Re: Bray to City Centre Core Bus Corridor Scheme Compulsory Purchase Order 2023
Bray to Dublin City Centre

Re:- Bray to City Centre Core Bus Corridor Scheme CPO 2023
Bord Pleanála Case reference: KA27.317780

Ref:- Plot List 1104 (1-6) and 1106 (1-2)

Bray to City Centre Core Bus Corridor Scheme Compulsory Purchase Order 2023
An Bord Pleanála Case reference: KA27.317780

Figure 2: Location of approved outdoor classroom

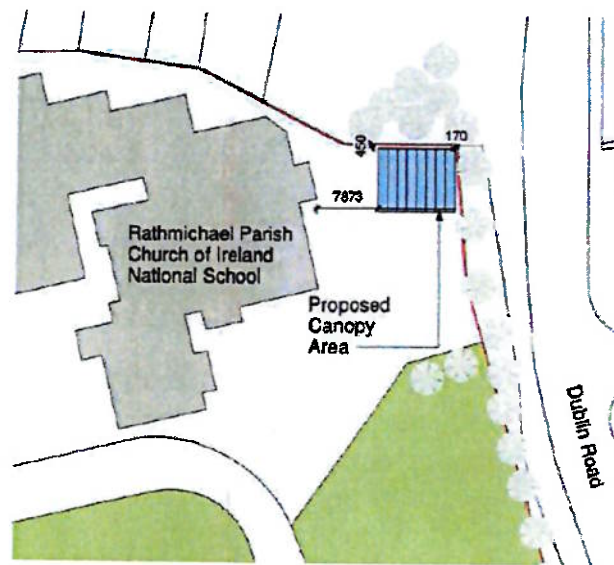
It should also be noted that planning permission was granted in May 2023 for the construction of an outdoor canopy for an outdoor classroom the north eastern corner of site immediately adjacent to the construction area (in location 6 in Figure 1 above). The existence of this proposal has not been factored into the Scheme design and the Board would require that its construction is not impacted by the Scheme.

Figure 3: Extract of Map 44: Emerging Preferred Route February 2019 (NTA)

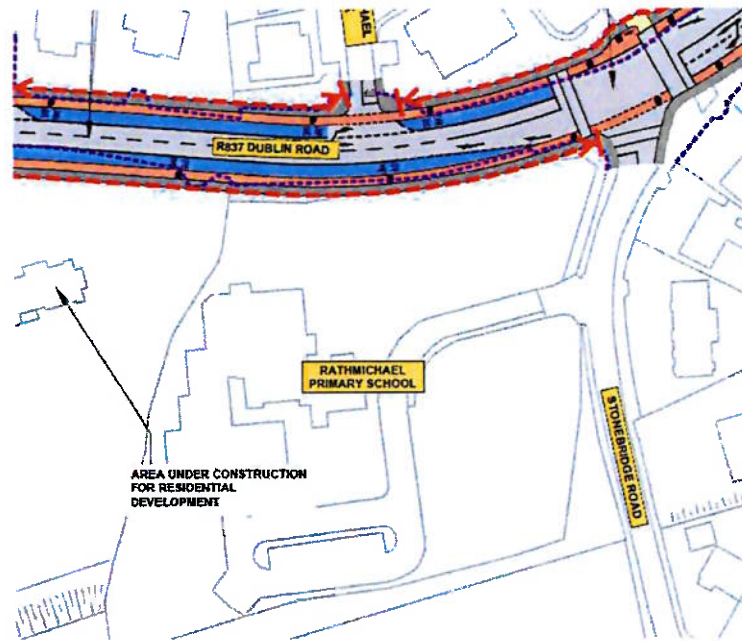
The Emerging Preferred Route that was the subject of public consultation in February 2019 indicated that one bus lane, one general traffic lane and a single segregated cycle track was to be provided in each direction on Dublin Road to St Anne's Church to the south. It was further indicated that the existing Dublin Road/Stonebridge Road junction was intended to be upgraded to facilitate bus priority. (See Figure 3 overleaf.)

Figure 4: Extract of Map 44: Preferred Route March 2020 (NTA)

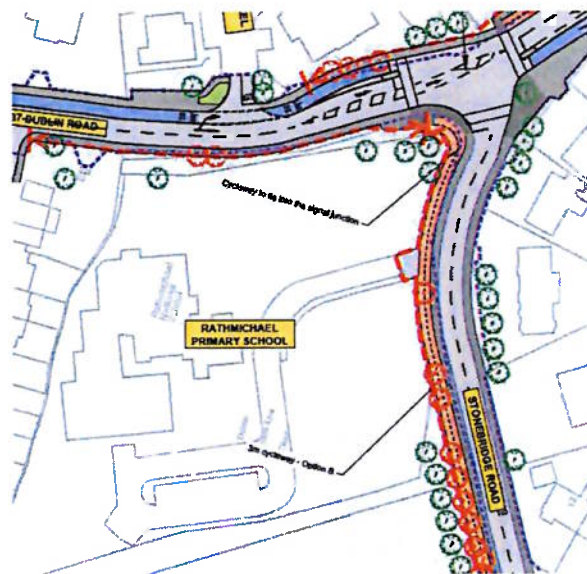
As a consequence of the consultation process, the Emerging Preferred Route was changed – the segregated cycle tracks on Dublin Road between Loughlinstown Roundabout and Stonebridge Road were omitted and a two-way cycle track from the Shanganagh Road/Dublin Road Junction along the Dublin Road and along Stonebridge Road as far as St Anne’s National School was included to provide a local cycle link to the two schools. The NTA stated that *“these proposals have been introduced following local community engagement and consideration of submissions from the public.”* (See Figure 4 below).

The Board considers that the proposal in the Scheme to provide cycle tracks along the northern side of Stonebridge Road must be reconsidered and should be reviewed with a view to omitting them from the overall Scheme as their benefit to connectivity in the wider area has not been assessed or justified in the Scheme.
